KIRKLEES METROPOLITAN COUNCIL INVESTMENT & REGENERATION SERVICE

Reference No:	2026/62/90705/W
Site Address:	17, Holstein Avenue, Bradley, Huddersfield, HD2 2GU
Description:	Erection of single storey rear extension
Recommending Officer:	Faiza Bano

HOUSEHOLDER DELEGATED REPORT

Application Number	2026/ 90705
Location	17, Holstein Avenue, Bradley, Huddersfield, HD2 2GU
Proposal	Erection of single storey rear extension
Publicity end date	12/06/2026
Number of representations received	None.
Kirklees Local Plan Allocation/Designation	Housing land allocation
Extension to Time (EoT)	Yes – 20th July 2026
Recommendation	Conditional Full Permission

Project/Client: 17 HOLSTEIN AVENUE BRADLEY HUDDERSFIELD HD2 2GU	Project No: AH0543 Dwg No: 2 Rev: D
Drawing: PROPOSED	Scale: AS SHOWN Drawn By: AH Date: 22/02/26 Checked By: AH

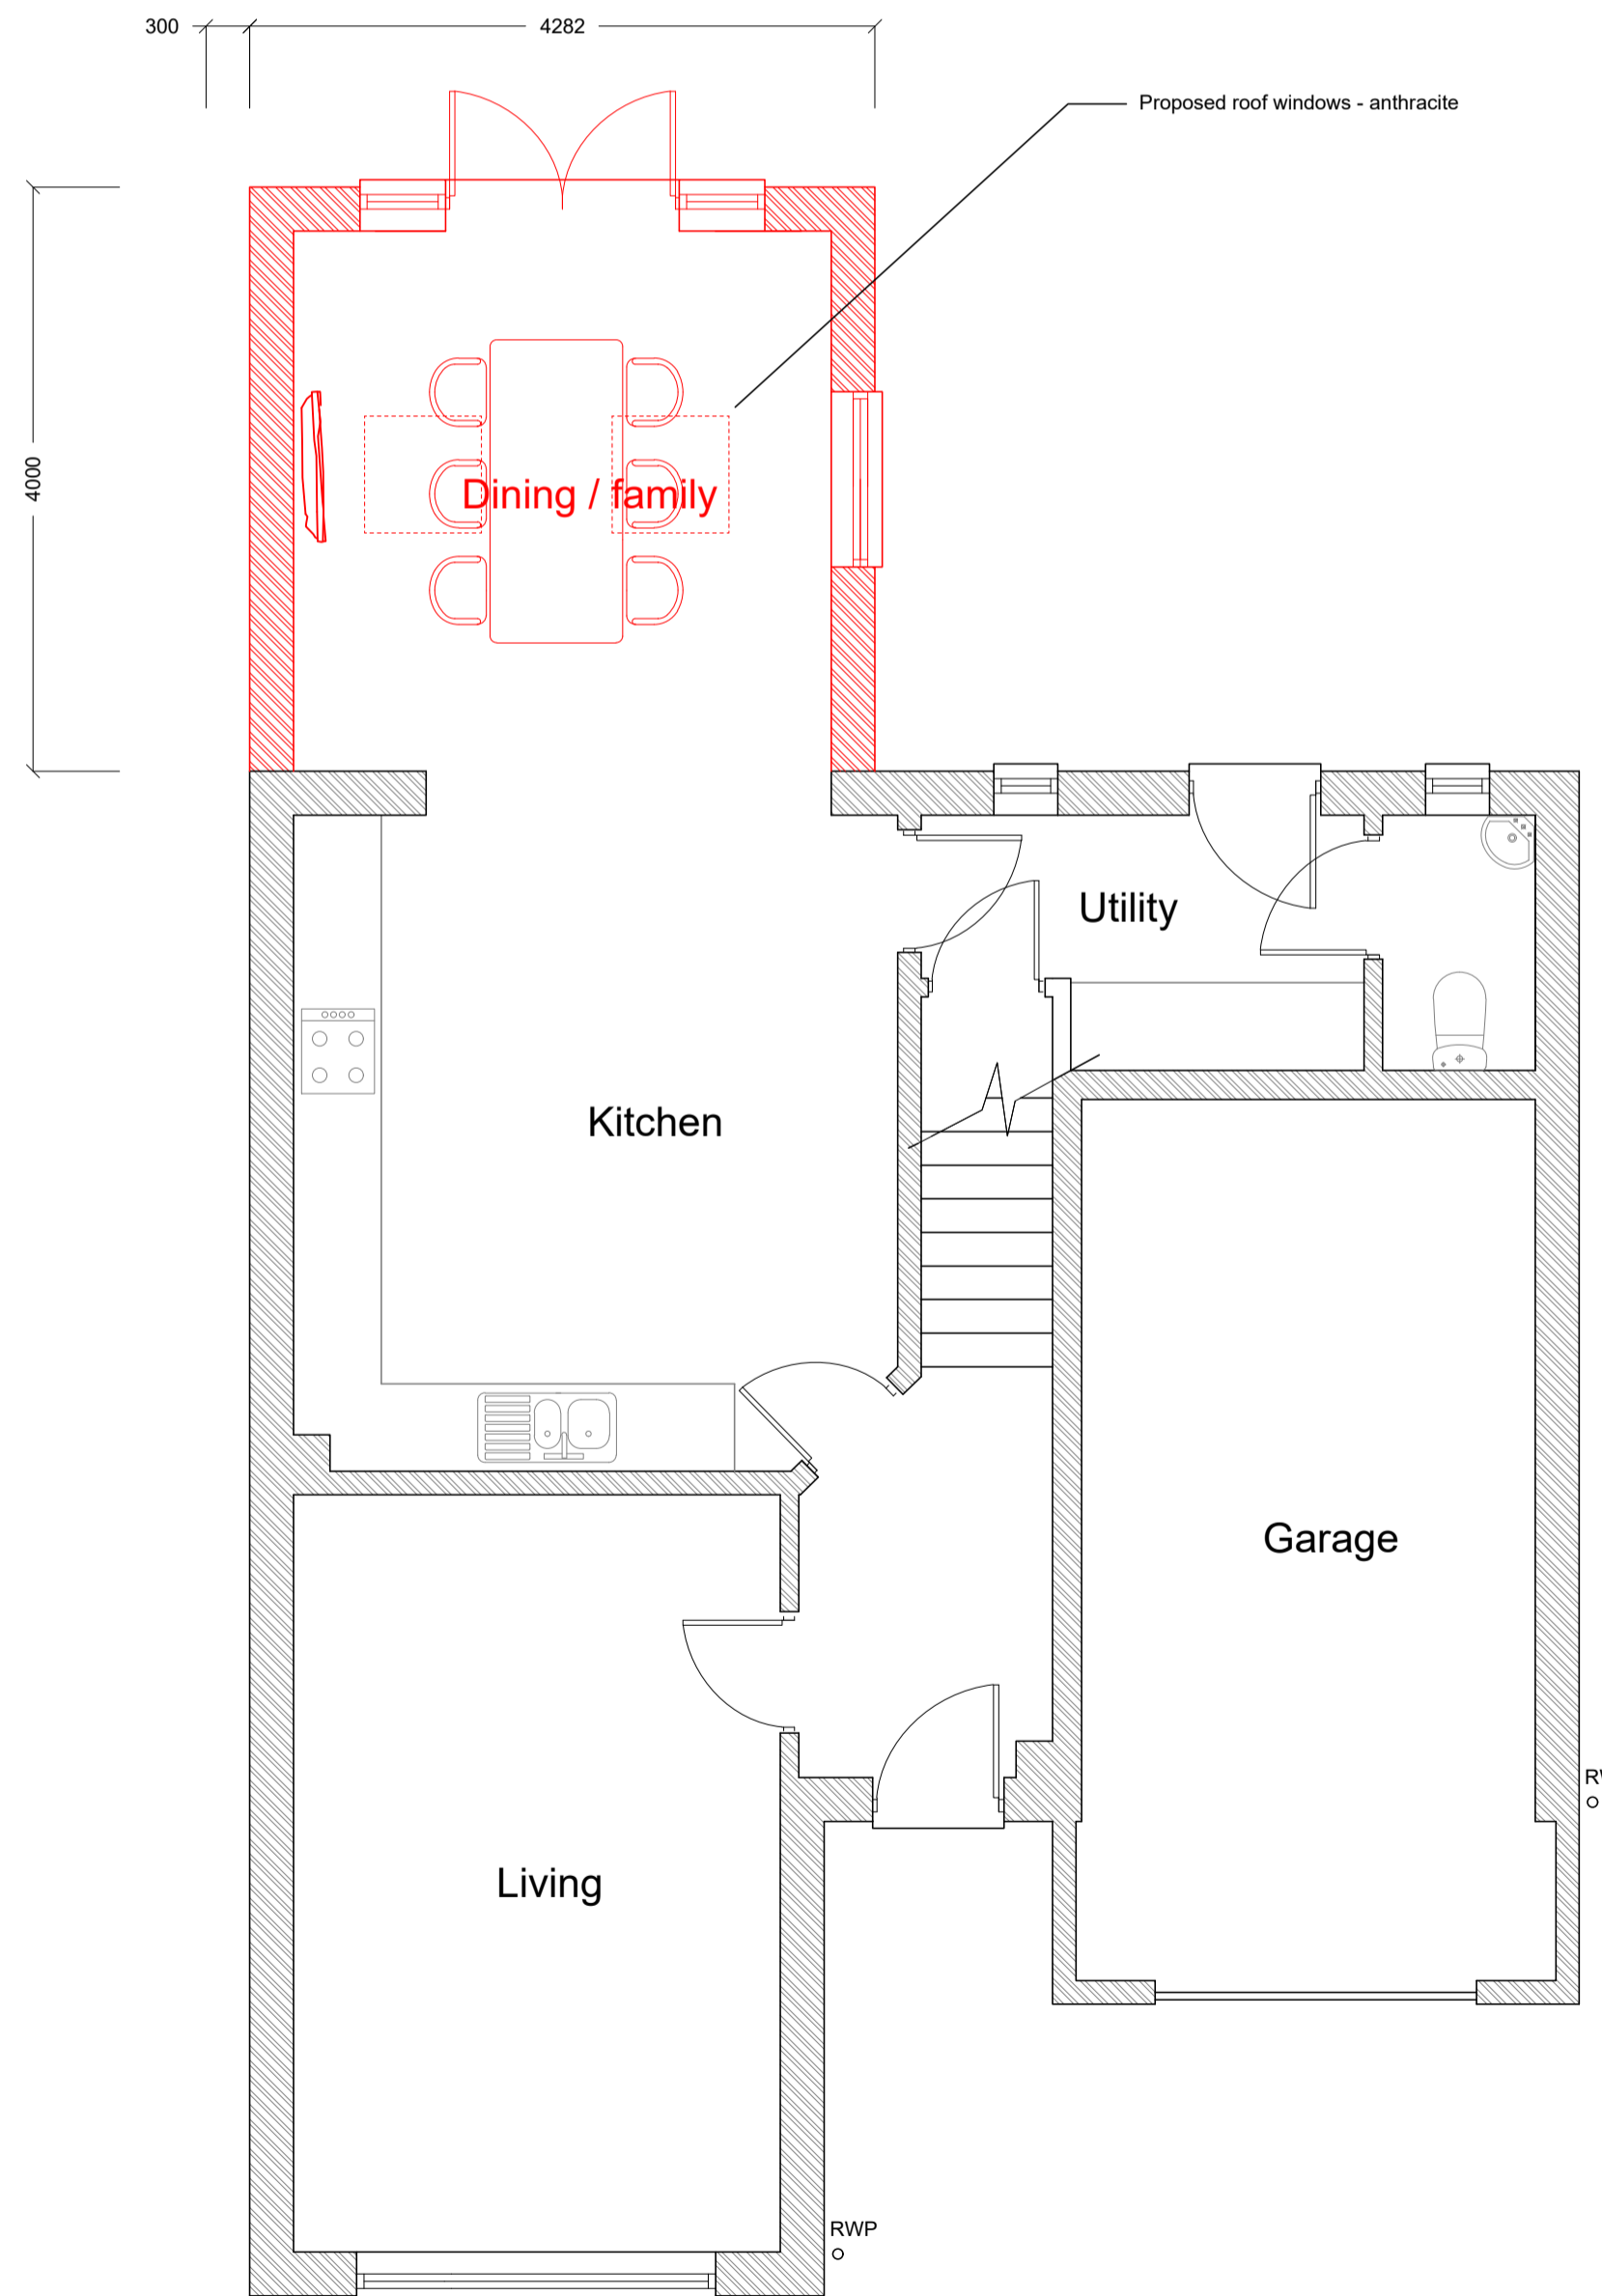
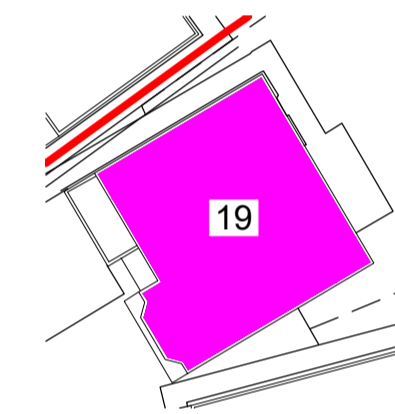
Rear Extensions Should:	<u>Yes - COMPLY</u>	<u>No - JUSTIFY</u>
respect the original house and garden in terms of its size and scale	Yes - the extension does not cover more than half of the total area around the original house. The proposed rear extension would project approximately 4 metres from the rear of the original dwellinghouse, would have an eaves height of 2.4 metres and is designed with a lean to roof.	
use appropriate materials which match or are similar in appearance to the original house; and	Yes – materials to match existing.	
not have an adverse impact by way of overshadowing or loss of outlook of neighbouring properties.	Yes – the dwelling is detached and due to the single storey nature of the proposed development, it will not overshadow neighbouring properties. The proposed extension is of a modest scale and there will be no impact on the loss of outlook of neighbouring properties. The extension is residential and will not be disproportionate to the site and neighbouring areas.

Relevant key design principle (KDP) of the SPD, Policy in the Kirklees Local Plan and the NPPF	Further comments	✓ / X / N/A
Impact on the Local character and street scene	• KDP1 of the SPD • Policy LP24 Design (a) and (c) of the KLP • Chapter 12 NPPF	The extension is generally modest in scale, the proposed development would not appear overly prominent. The proposed development would be located to the rear of the property and will not impact the character or street scene across the frontage of the property.	✓
Impact on original house	• KDP2 of the SPD • Policy LP24 Design (c) and (d) of the KLP • Chapter 12 of the NPPF	The original property would remain the dominant feature.	✓
Height, scale and massing	• KDP 1 and 2 of the SPD • Policy LP24 Design (a), (c) and (d) of the KLP • Chapter 12 of the NPPF	As above. The extension would project across the rear of the property and is single storey.	✓

There will be no significant impact on this dwelling given that the proposal is located away from the shared boundary and is single storey in design. A window would face the shared boundary with no.19, the intervening boundary treatment and siting of this window away from the boundary is such no unacceptable level of overlooking is envisaged to occur. The distance of the proposal from no.19 is such it would not lead to unacceptable levels of overlooking or be unduly oppressive.

There will be no significant impact on this dwelling given that the proposal is located away from the shared boundary and is single storey in design and the siting of the proposal ensures an adequate distance which is such that there would be no unacceptable levels of overlooking arising. The distance between this property and the proposal would ensure no unacceptable overshadowing or that the proposal would be unduly oppressive.

property also has a driveway big enough to fit a car after the construction of the proposed rear extension.	
Parking provision	• KDP 15 of the SPD • Policy LP22 Parking (f) of the KLP • Chapter 12 of the NPPF	Maintains appropriate access and off-street in-curtilage parking.	✓
Provision for waste storage	• KDP 16 of the SPD • Policy LP24 Design (d) (iv) • Chapter 12 of the NPPF	None shown on plans however, there is sufficient space within the red line boundary to allow for storage on site. Condition not considered necessary.	✓

3. The external walls and roofing materials of the extension hereby approved shall in all respects match those used in the construction of the existing building and be retained thereafter.
